Andrew Hartcher - Proposed Modification – Orange Waste Project Application 09_0025 MOD 1

Proposed Modification – Orange Waste Project Application 09_0025 MOD 1

EUCHAREENA ROAD
SITE COMPARISON

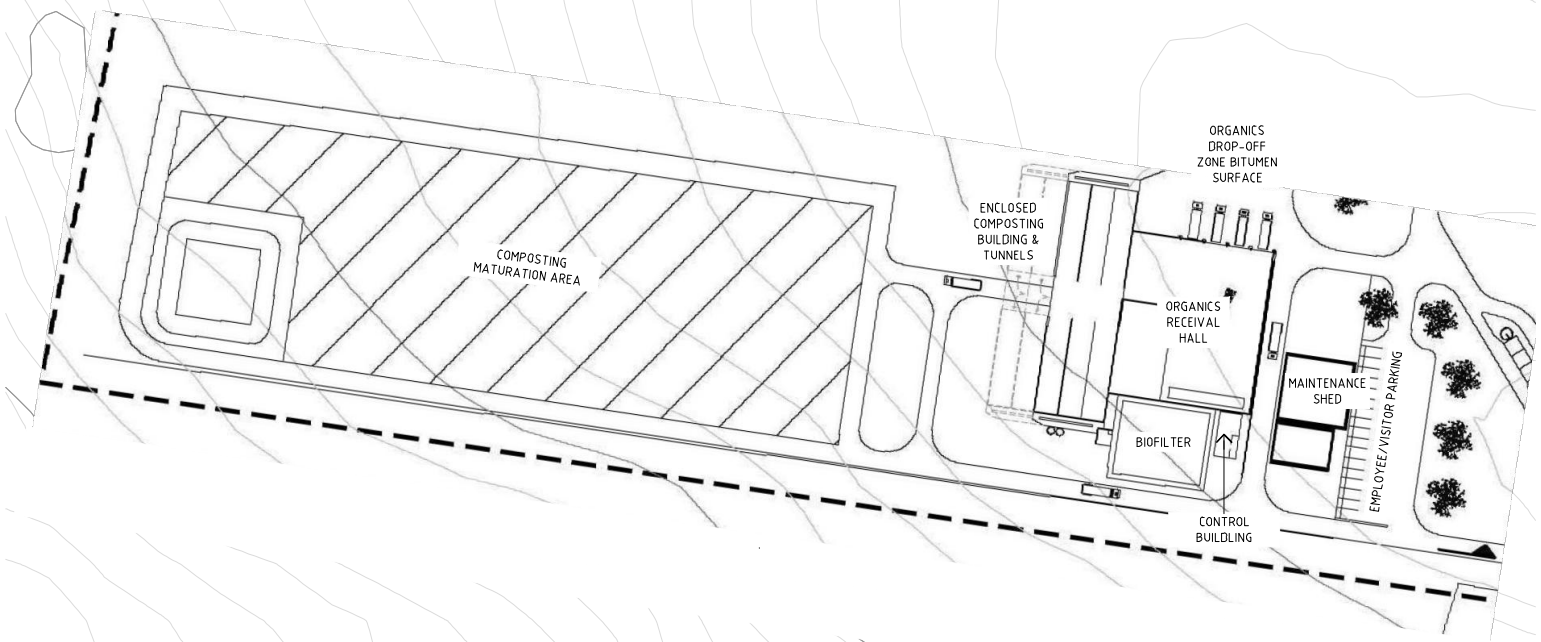
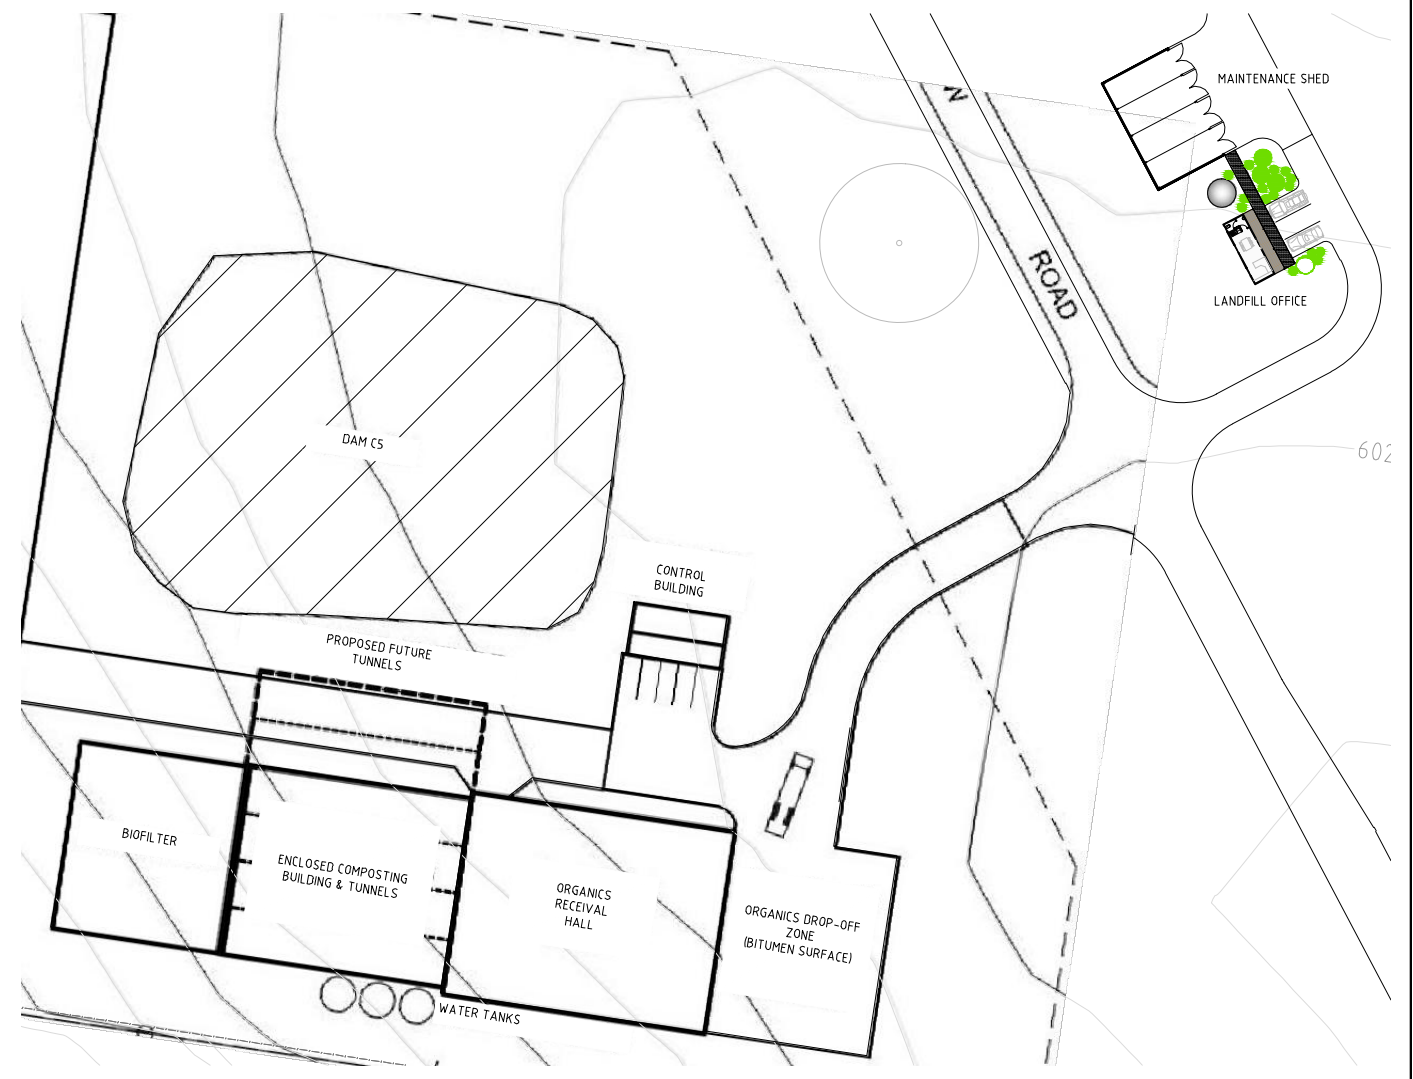
Additional dams – It is proposed that a single dam (Dam C in the EA) be replaced with 5 dams with a total storage capacity of **10ML**. Appendix J Surface Water Assessment for the EA stated that the capacity of Dam C was **0.5ML** and its purpose was for collection of runoff from the maturation pad. In the Surface Water Assessment it was intended to be sealed from access by bees. However, in the EA the base of it was to be lined to prevent leaking into surrounding soils and there was no size specified.

- The EA, at C.4.2.4 Site water balance, states *“The annual water requirement for operation of the enclosed composting plant would be zero. In fact, a small surplus of water may be generated.”* How is this proposal a minor modification and how have its impacts been assessed?

- The source, quality and end use of the water in these proposed dams have not been clearly stated. For example, there is reference to water saving “for reuse”. If the water is “reused” via the composting process, it will inevitably become contaminated as, no matter how good the screening process, the composting material will include some contaminated material eg batteries, chemical residues. As a result of issues raised in the Hub court case and the Director General’s requirements for the Part 3A application for this proposal in respect of impacts of access by bees to contaminated water, the landfill leachate system is internal (with no leachate ponds). This proposal appears to directly contradict these measures. It also appears that these dams will occupy a vast tract of land. These will inevitably attract bees creating a biosecurity risk to the bees and their produce (as they drink contaminated water and as they are more likely to access the immediately adjoining composting facility/receival shed).

- Will these dams be lined to prevent leaking into surrounding soils as originally proposed for Dam C?

- The EA states (Surface water flows p C.4-15) *“The maximum dam capacity harvestable right appropriate to the Euchareena Road Site is $192.6 \times 0.07 = 13.5$ ML.”* The EA went into detail as to compliance with harvestable rights. This is not addressed. What is very concerning is that the proponent has concurrently lodged an application with Cabonne Council to subdivide off the composting facility site (a 4.97 ha block) . The proposed 10ML storage would significantly exceed the harvestable right for a block of 4.97ha (i.e. $4.97 \times 0.07 = 0.3479$ ML).

2 PROPOSED SOUTHERN ELEVATION

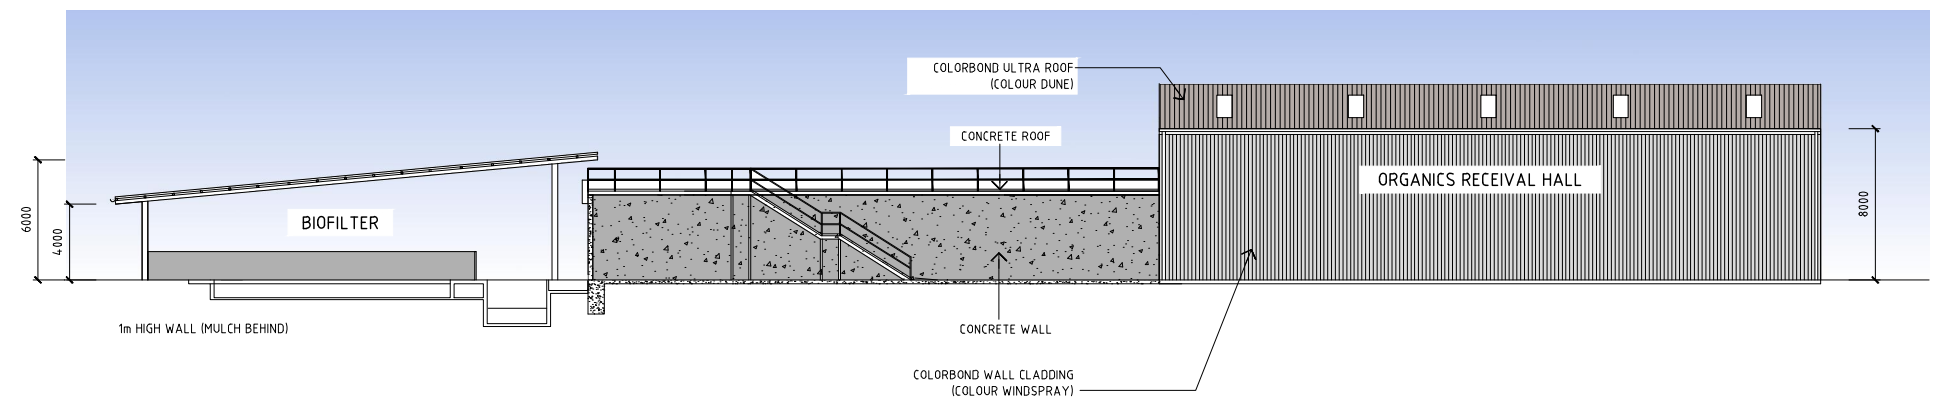
- The diagram does not clearly show how the facility satisfies the revised definitions of “enclosed tunnel” and “receival and transfer area”. In particular, we remain very concerned that original approval was on the basis that the facility would include a *“door that would be locked hermetically to contain any odours and leachate and to prevent access by bees”*: C1.5.2. All air quality and noise assessments in the EA were done by consultants who were provided with diagrams of the proposed composting facility as included in the EA. These did **not** include a completely open ended shed. Clarifications, waivers and minor modification upon minor modification could ultimately result in something which is different in a fundamental aspect to the approved development and undermines the system.

- The building has been realigned. The open side of the receival hall is in a direct line with Mr Gosper’s residence. The proponent is over simplifying the noise impacts. The side wall of the previous alignment acted as a buffer to sound generated in the receival hall. The south westerly prevailing winds will direct the noise towards Mr Gosper’s residence. This is of particular concern as the hours of operation for the **indoor** composting activities can be conducted 24/7 (Approval P12 Operating Hours Condition 27).
